Consultation Response from KC, Highways Development Management
2023/93714 Land off, Cumberworth Lane, Denby Dale, Huddersfield, HD8 8RU
Reserved Matters application (including the consideration of access, appearance, landscaping layout, and scale) for the erection of 10 dwellings pursuant to outline permission 2019/93906 for erection of residential development up to 10 dwellings, and discharge of condition 20 (waste arrangements)
Date Responded: 5-8-2024. Responding Officer: Mark Berry. Responding Ref: 17-12-24.

This application seeks approval to the Reserved Matters application (including the consideration of access, appearance, landscaping layout, and scale) for the erection of 10 dwellings pursuant to outline permission 2019/93906 for erection of residential development up to 10 dwellings, and discharge of condition 20 (waste arrangements) at land off, Cumberworth Lane, Denby Dale, Huddersfield,

The applicants have provided revised plan numbers 23-058-01D (Site Plan as Proposed) and 23-058-11C (Sections as Proposed) together with house type plans.

Drawing:
Sections As Proposed

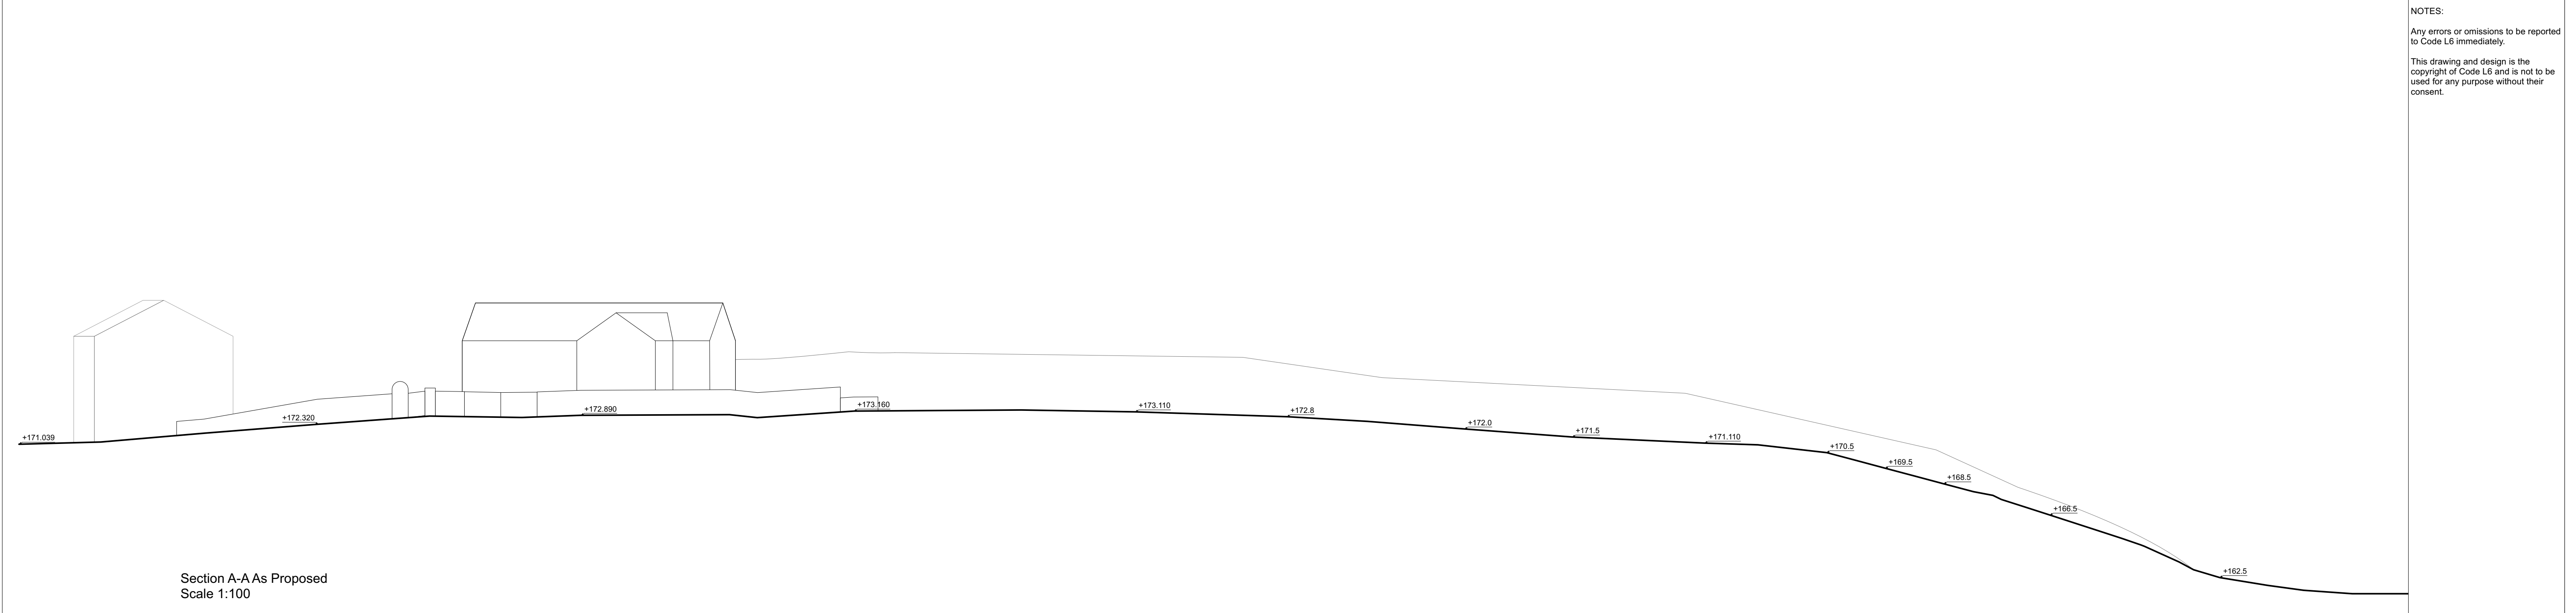
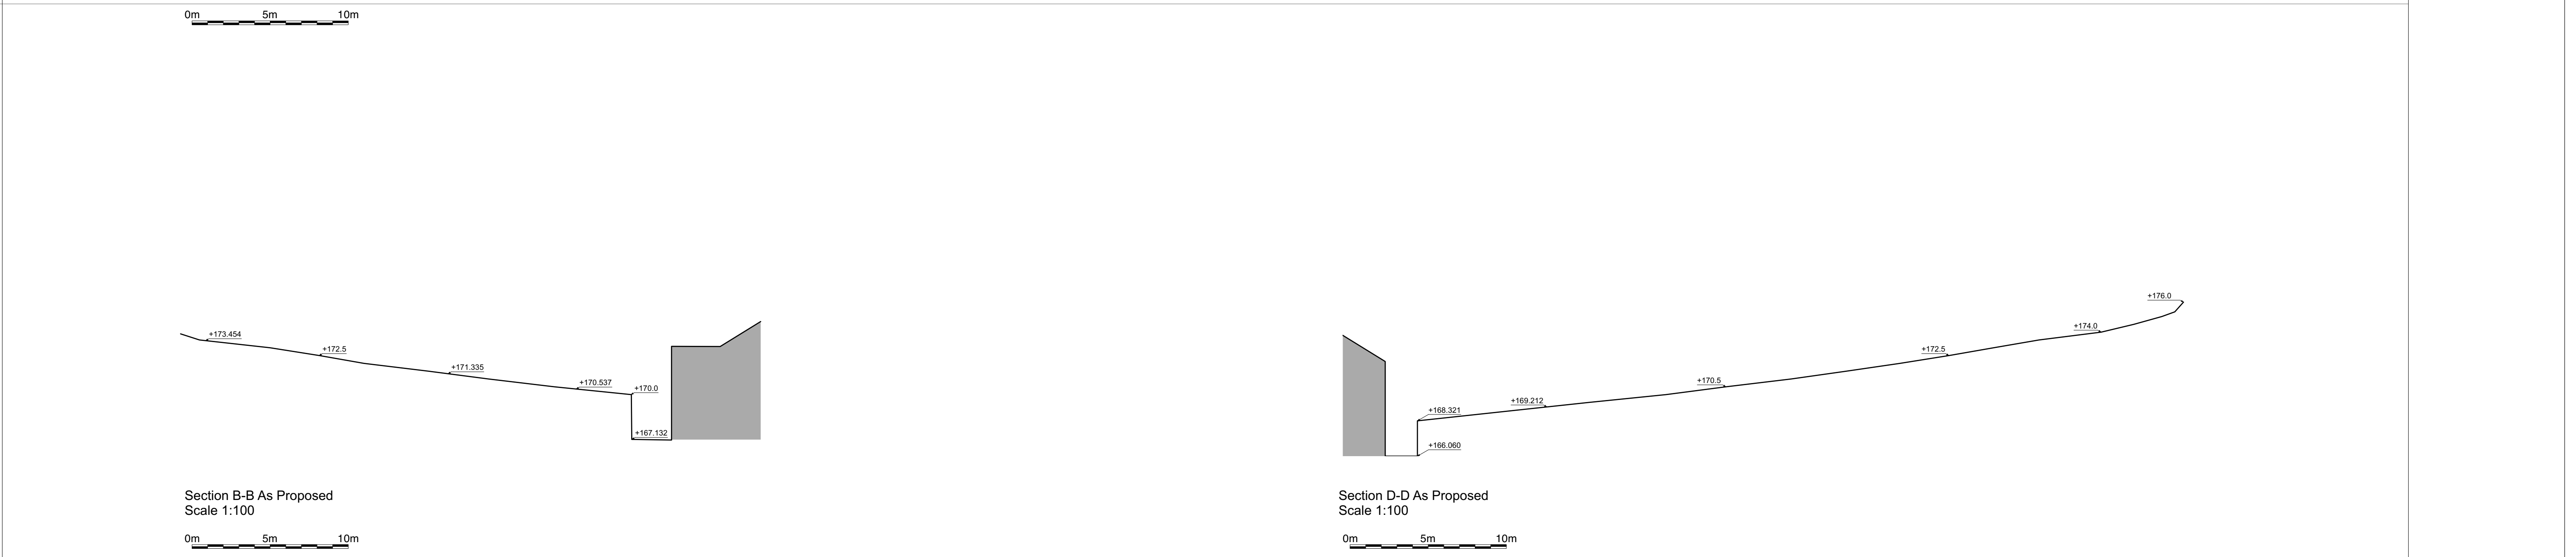
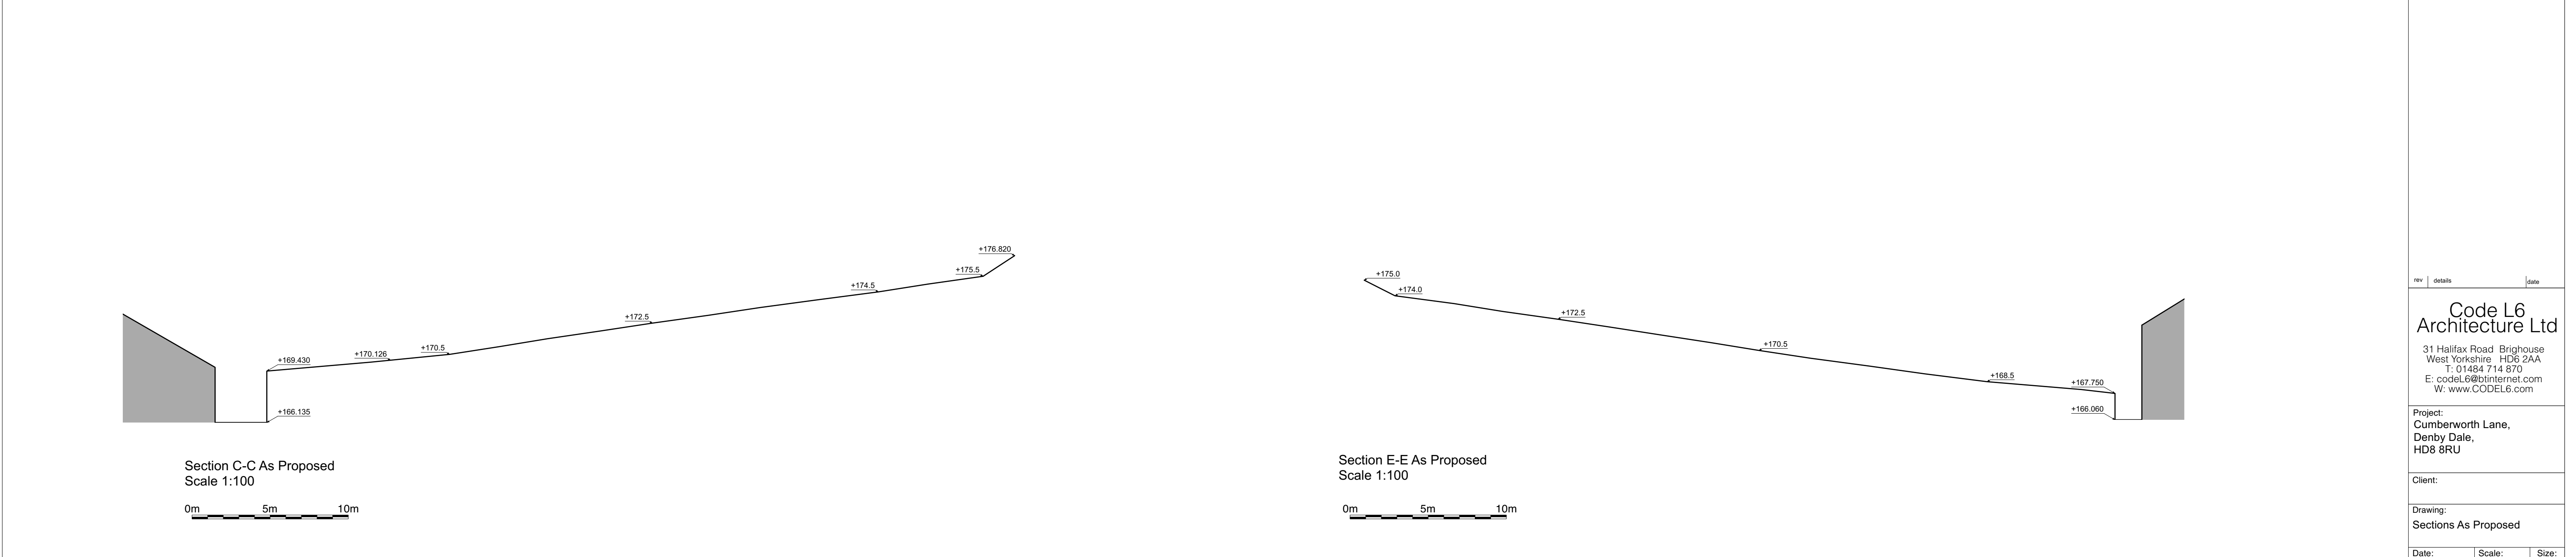
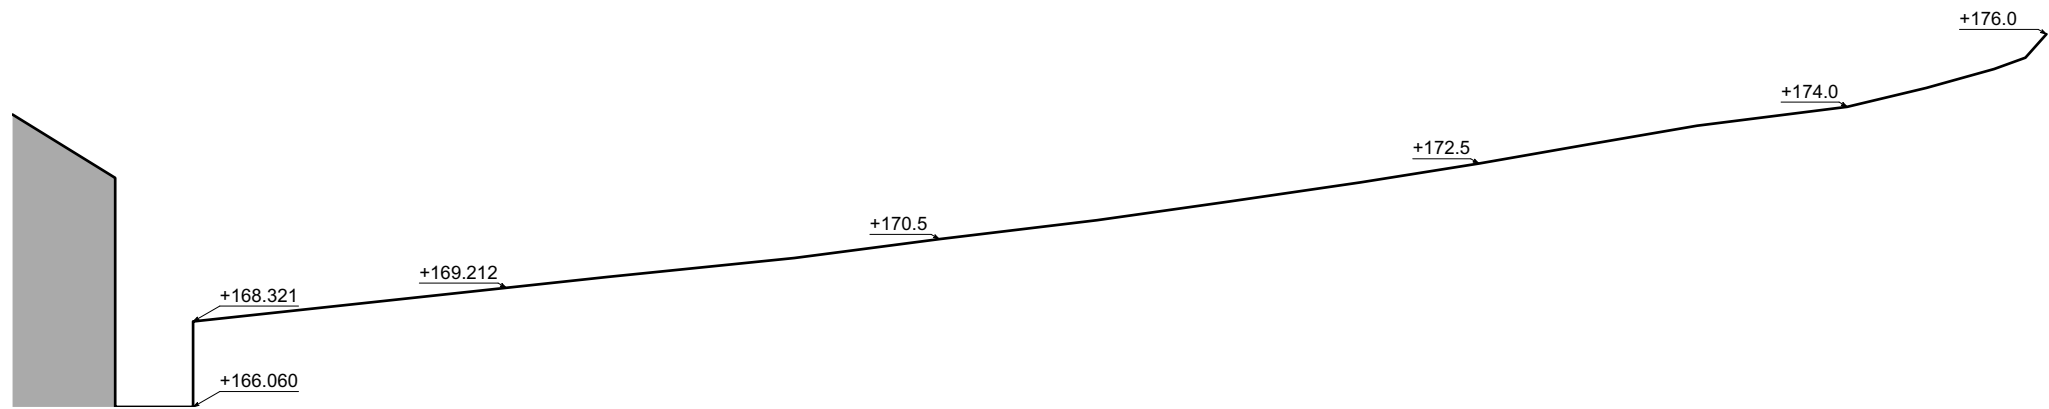
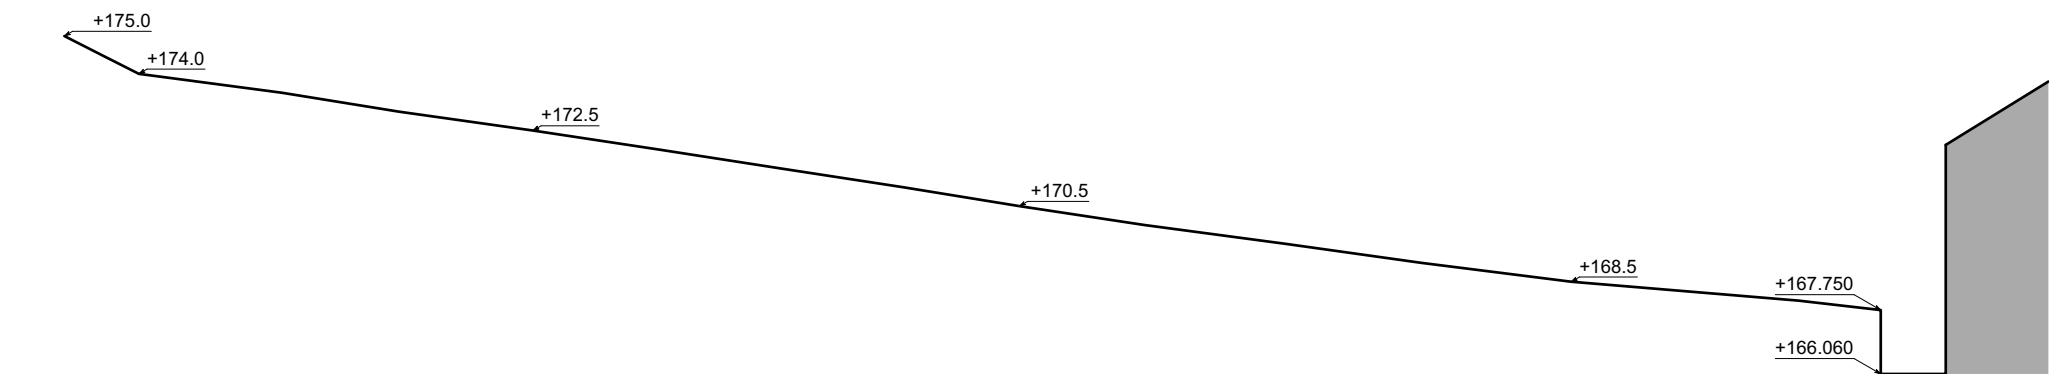
- 7, The Design and Access statement refers to the general highway arrangement details being shown on drawing number 23-056-10. This is not provided.*
- 8, When the layout is agreed a stage one road safety audit should be provided for the access from Cumberworth Road and the internal road layout.*

As far as the reserved matters application is concerned the revised plans address the points raised other than point 5 above. Visitor parking should be available for all to use and not contained within the curtilage of individual plots. 2 or 3 spaces parallel to the roadway between plots 1 and 2 and the turning head would be sufficient.
